**WEST SUSSEX COUNTY COUNCIL
PLANNING SERVICES CONSULTATION**

SUBJECT: A/11/17/OUT

Hybrid Application to include Full planning permission for a retail unit (Class A1) comprising 1,487sqm with associated access, car parking, servicing, landscaping & associated works & Outline planning permission with some matters reserved (scale & appearance) for public house (Class A4) comprising 581sqm (resubmission following A/23/15/OUT).

Land south of, New Road (A259) & East of Brook, Angmering

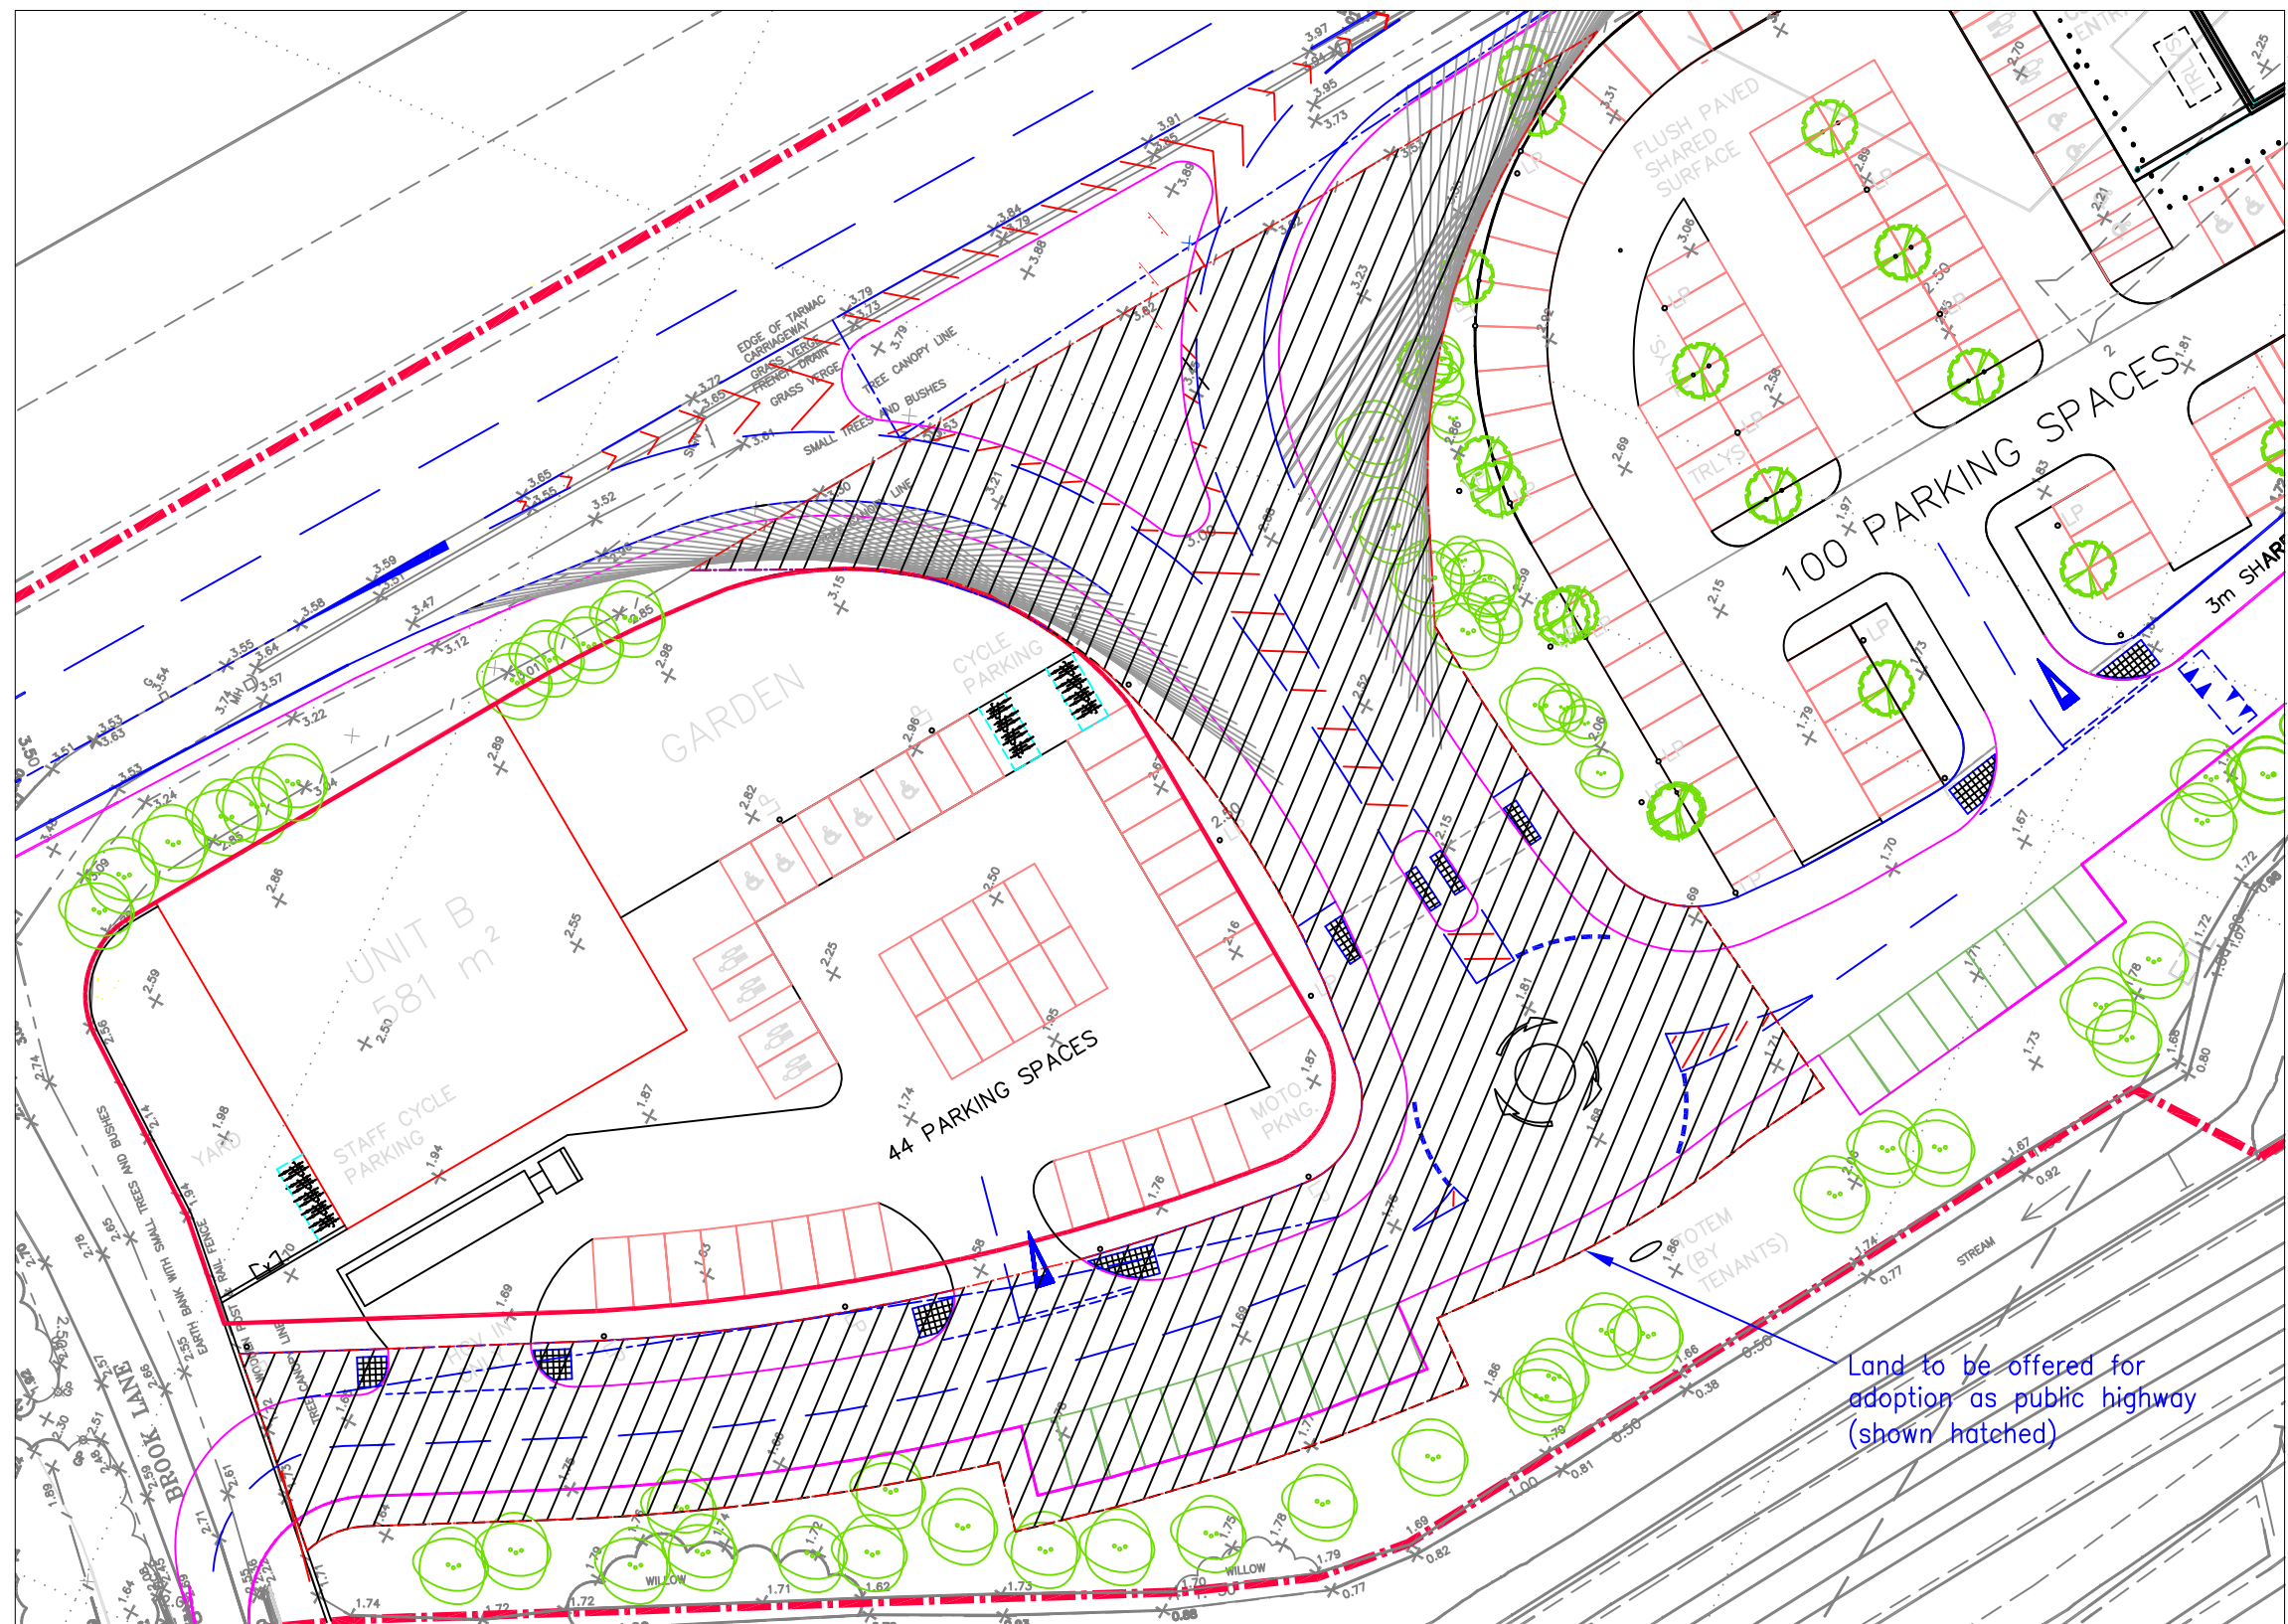
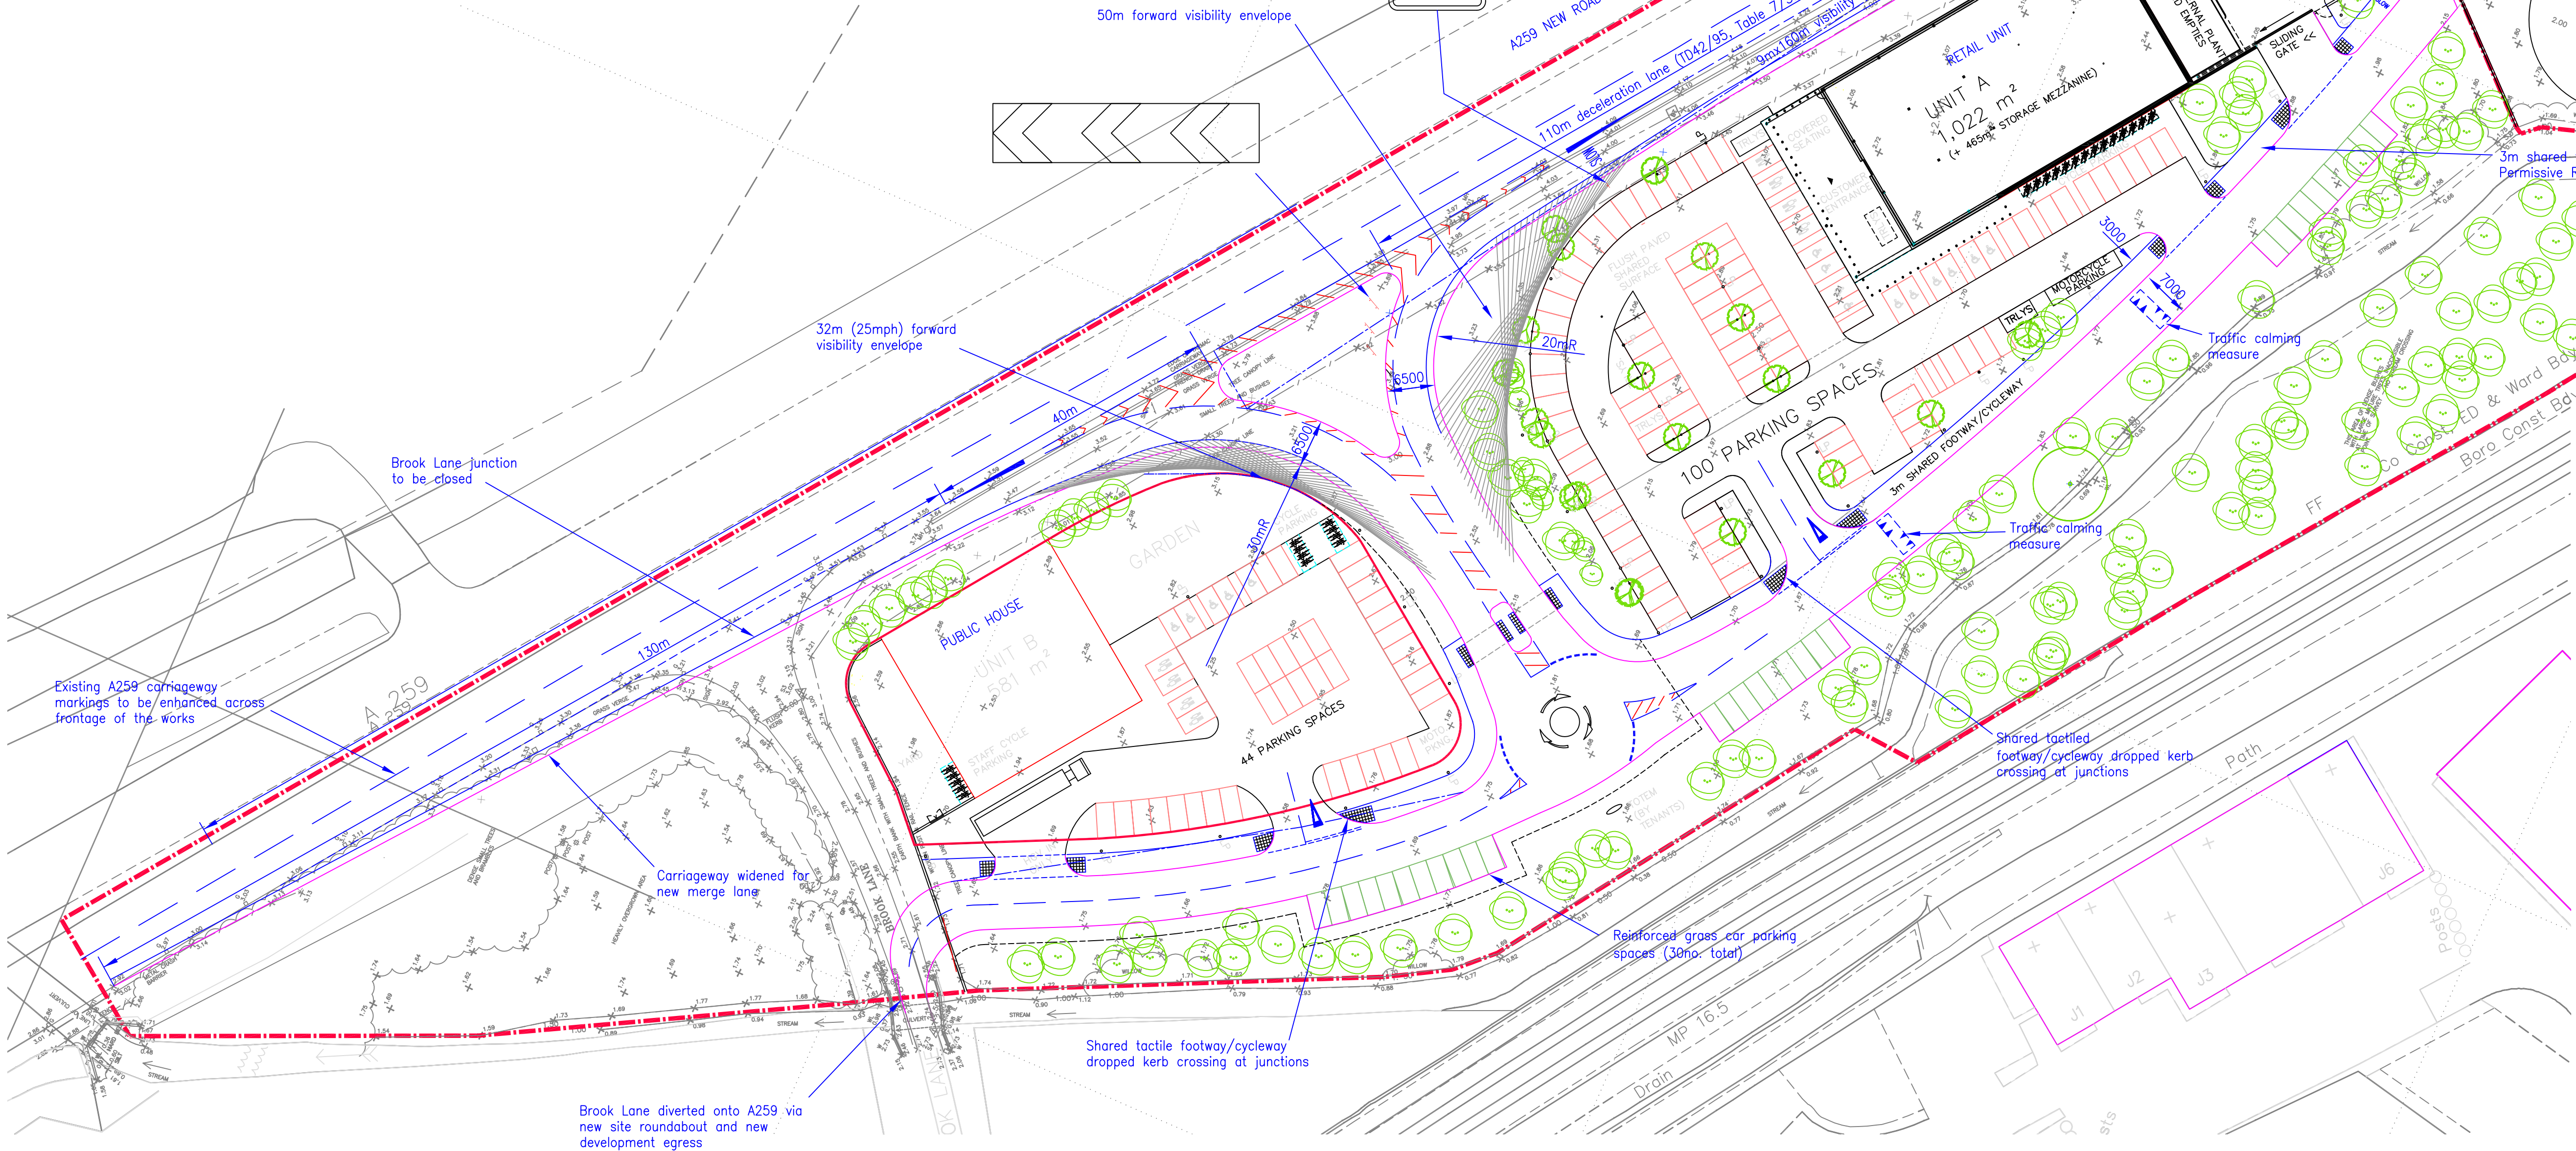
Further information has been supplied in respect of this matter raised in the Audit and reviewed by the WSCC Lead Safety Auditor. The weaving distance of 90m is accepted, and advanced warning signage shall also be installed that shows the layout of the successive junctions. The location and specification of the signage shall be agreed at the detailed design. An Exception Report to clarify the acceptance and a signed copy of this document shall be forwarded to the Planning Authority once complete.

The Applicant has indicated that they would wish to offer the site access, mini-roundabout and access south of the public house to the western boundary for adoption. WSCC would not adopt the on-site internal roads at this time, but will accept an adoption that includes the entirety of the splitter island and the section of roads immediately adjacent to the left in, left out junction onto the A259.

In addition, the sharp bend at the western end of the site by the existing bridge over the Brook would not be suitable for adoption and would require redesign if included as part of any future residential scheme offered for adoption. However, given that the road is to remain un-adopted and that it is outside of the public highway, the LHA does not object to the design remaining in its current format.
